WEST SUSSEX COUNTY COUNCIL CONSULTATION

TO:	Arun District Council FAO: Michael Eastham
FROM:	WSCC - Highway Authority
DATE:	29 September 2021
LOCATION:	Phase 2B Hampton Park Toddington Lane Littlehampton BN17 7PL
SUBJECT:	LU/283/21/DOC Approval of details reserved by condition imposed under ref LU/47/11 relating to Condition Nos 22 - Construction Method Statement, 23 - Construction Compound, 25 - vehicle wheel cleaning facilities & highway cleaning strategy and 26 - layout & specification of and construction programme for roads, footpaths, cycleways & parking areas.
DATE OF SITE VISIT:	n/a
RECOMMENDATION:	Advice
S106 CONTRIBUTION TOTAL:	n/a for purposes of this planning application

title
SURFACE TREATMENTS DRAWING
(SHEET 1 OF 3)

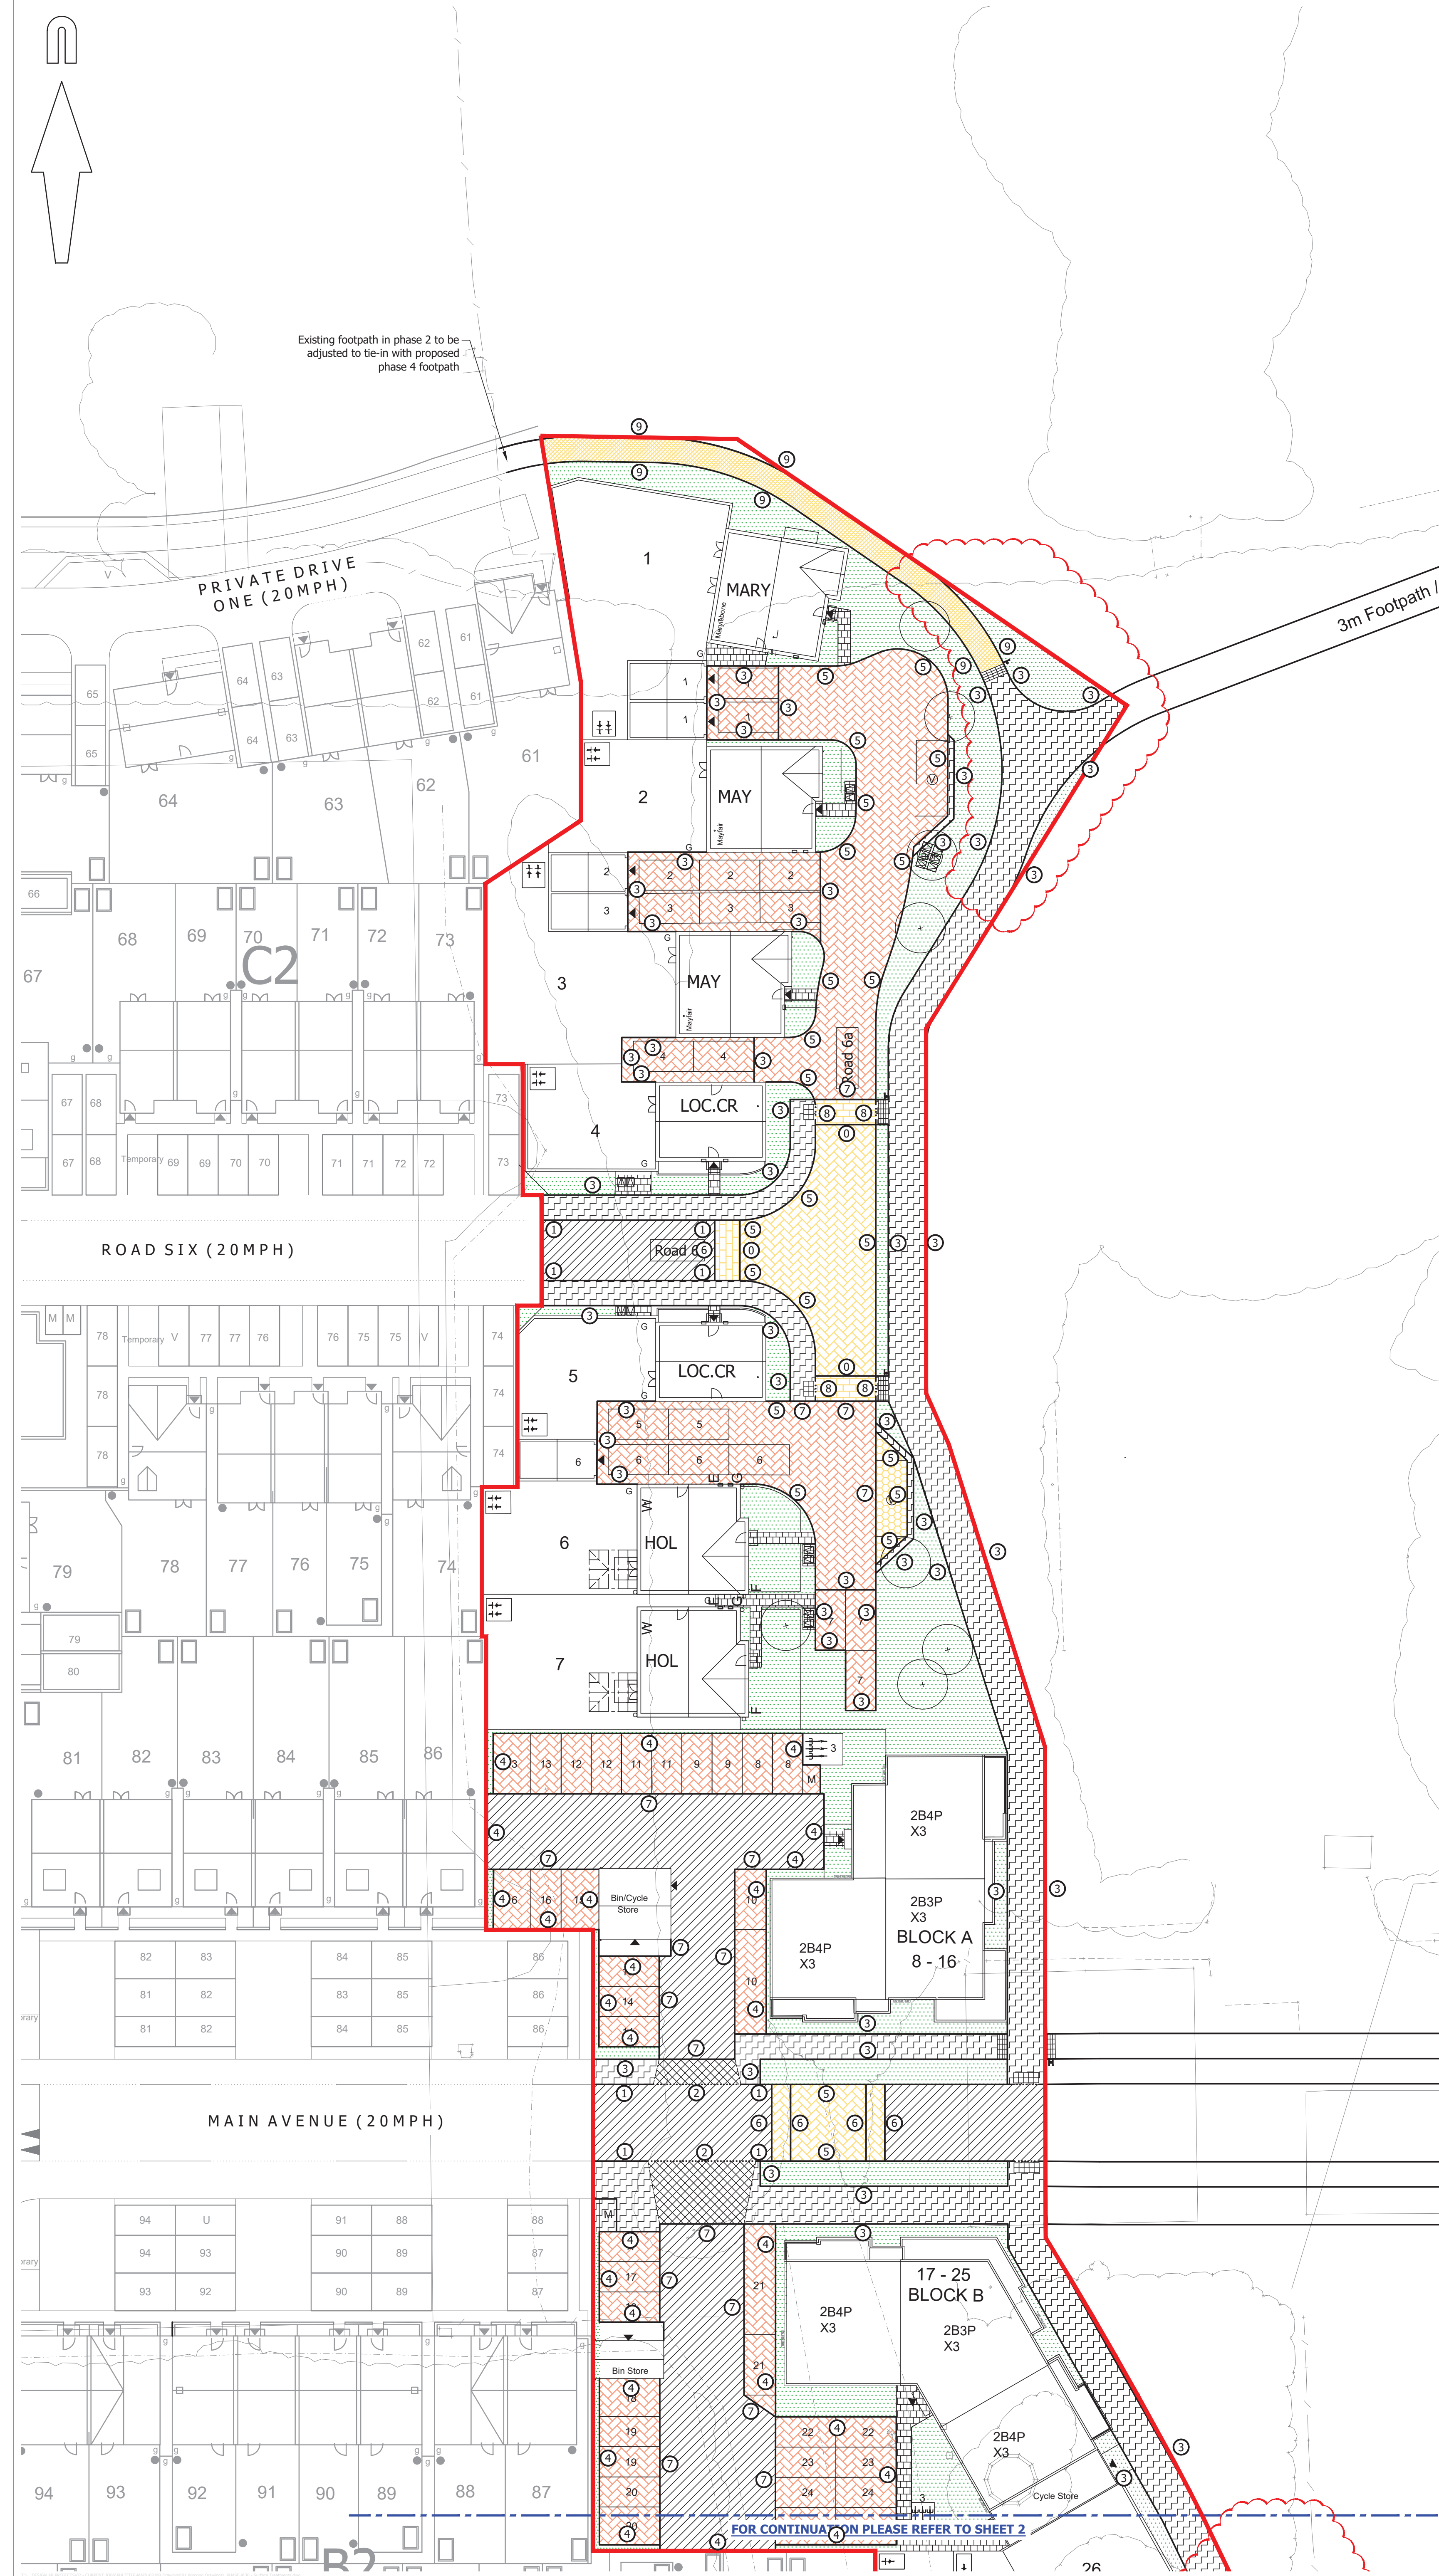
Condition 26 – The CHA will only respond to materials being used for areas being offered for adoption. As submitted, those materials shown on the areas proposed to be offered for adoption - i.e. the spine road and on immediately adjoining paths and crossovers etc. appear to meet WSCC specification. However, for the raised table on the section of the spine road included within the planning application, WSCC recommends that blockwork not to be used given the maintenance issues that can arise with it. Therefore, flexible material would be sought. The final position of the feature might also benefit moving eastwards to better pick-up the N-S shared foot/cycle route and to move it away from the access points serving the apartment blocks. WSCC would review this and the associated signage, markings and materials at the S38 stage.
